20171408.3/1806A/R2/TT

24/06/2019

Bulli Aged Care Centre of Excellence, 22 Hospital Road, Bulli - Condenser Relocation - Acoustic Advice

1 ELEVATION 3 - LHD NORTH
1:100

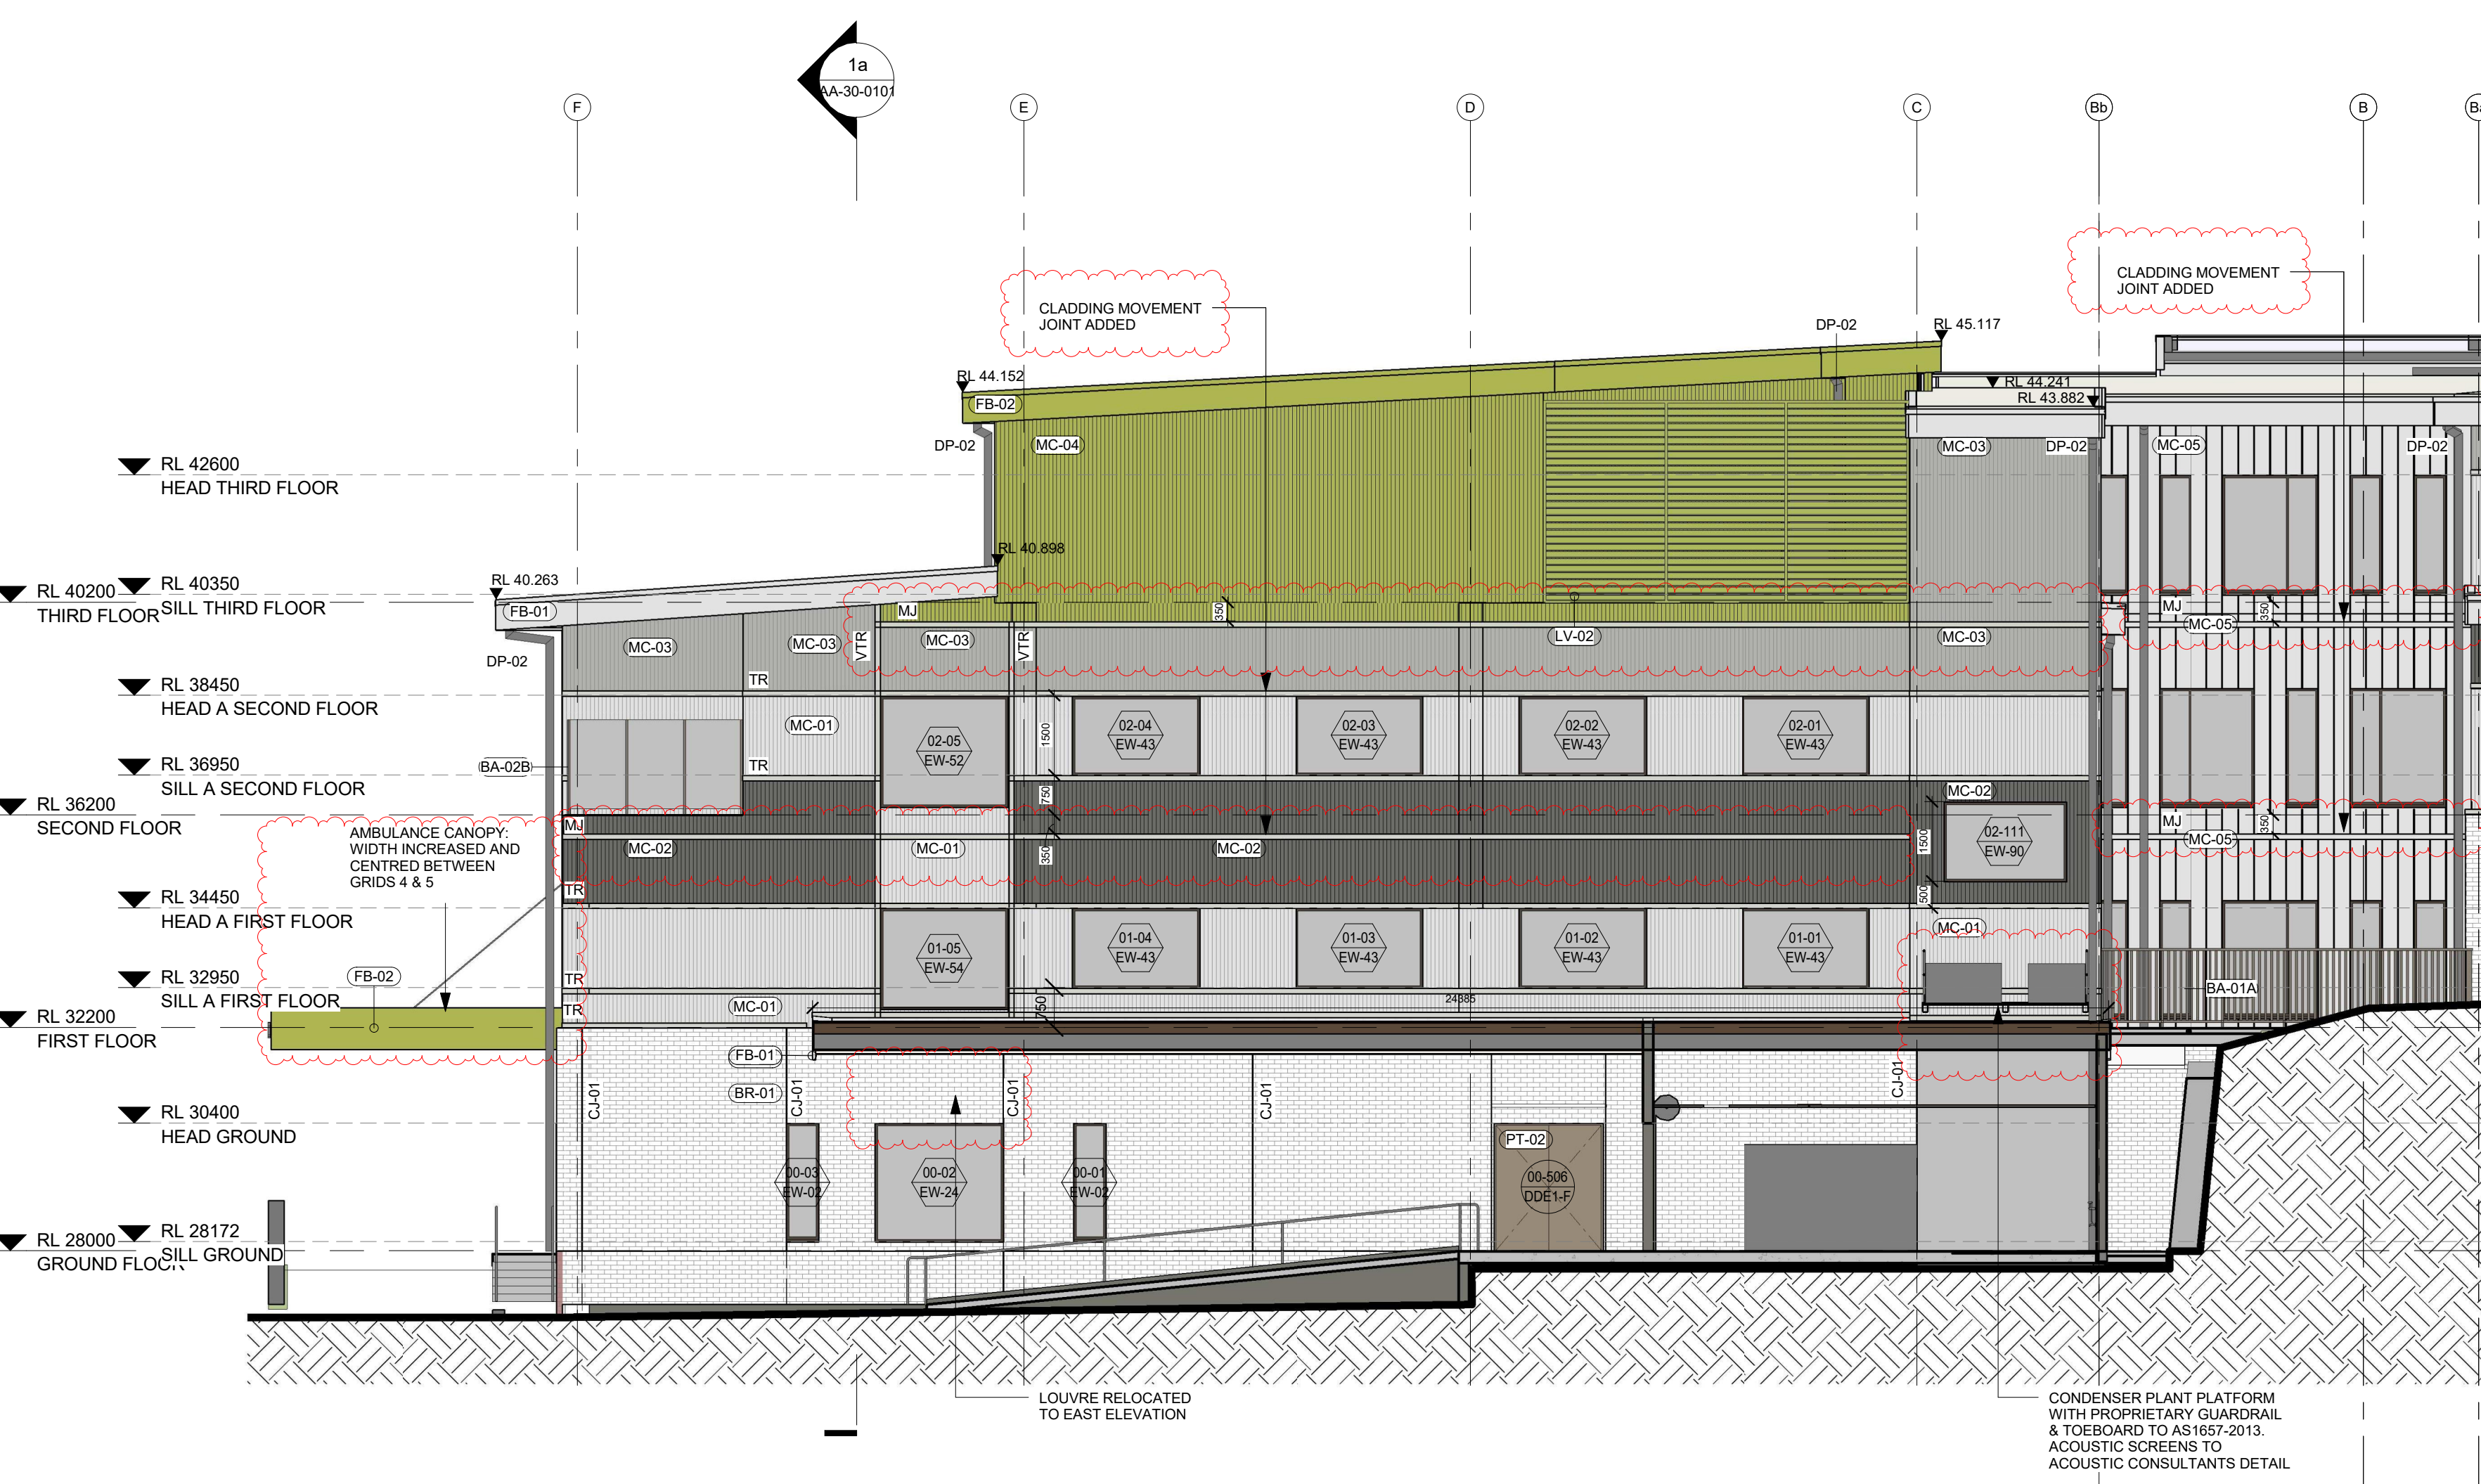
- Proposed condensers consist of:
 - 2 Mitsubishi PUHZ-RP170 units serving the comms room (52dB(A) at 1m distance).
 - 3 ACPAC condensers serving the cool room (AP4.1M1-4 and AP4.8L2-4, sound power 70-71dB(A)).
- The condensers are proposed to be located on a condenser platform on Level 1 of the northern façade.
- The nearest noise sensitive development to the condensers are residences directly to the north (Organs Road).

Condition of consent E7 requires that plant/equipment noise not exceed background noise levels by more than 5dB(A) above background levels. Night time background levels at the site are 30dB(A), making a noise emission limit of 35dB(A).

In order to ensure that compliant noise emissions from the condensers are achieved:

- Install an acoustic louvre (150mm deep, CVS or equal) between the comms room condensers (located at the northern edge of the deck) and the cool room condensers (at the southern end of the deck).
- Louvre must be minimum 400mm higher than the top of the cool room condensers.
- Louvres to return along the eastern and western sides of the plant deck.
- Install a piece of 0.5mm sheet metal/6mm fc sheet running east/ between the bottom of the deck and the roof below (below the lien of the acoustic louvre).
- Condensers to be mounted on Embelton NRD mounts or equal.
- Comm room condensers should use a night quiet mode between 10pm and 7am (49dB(A) at 1m distance).
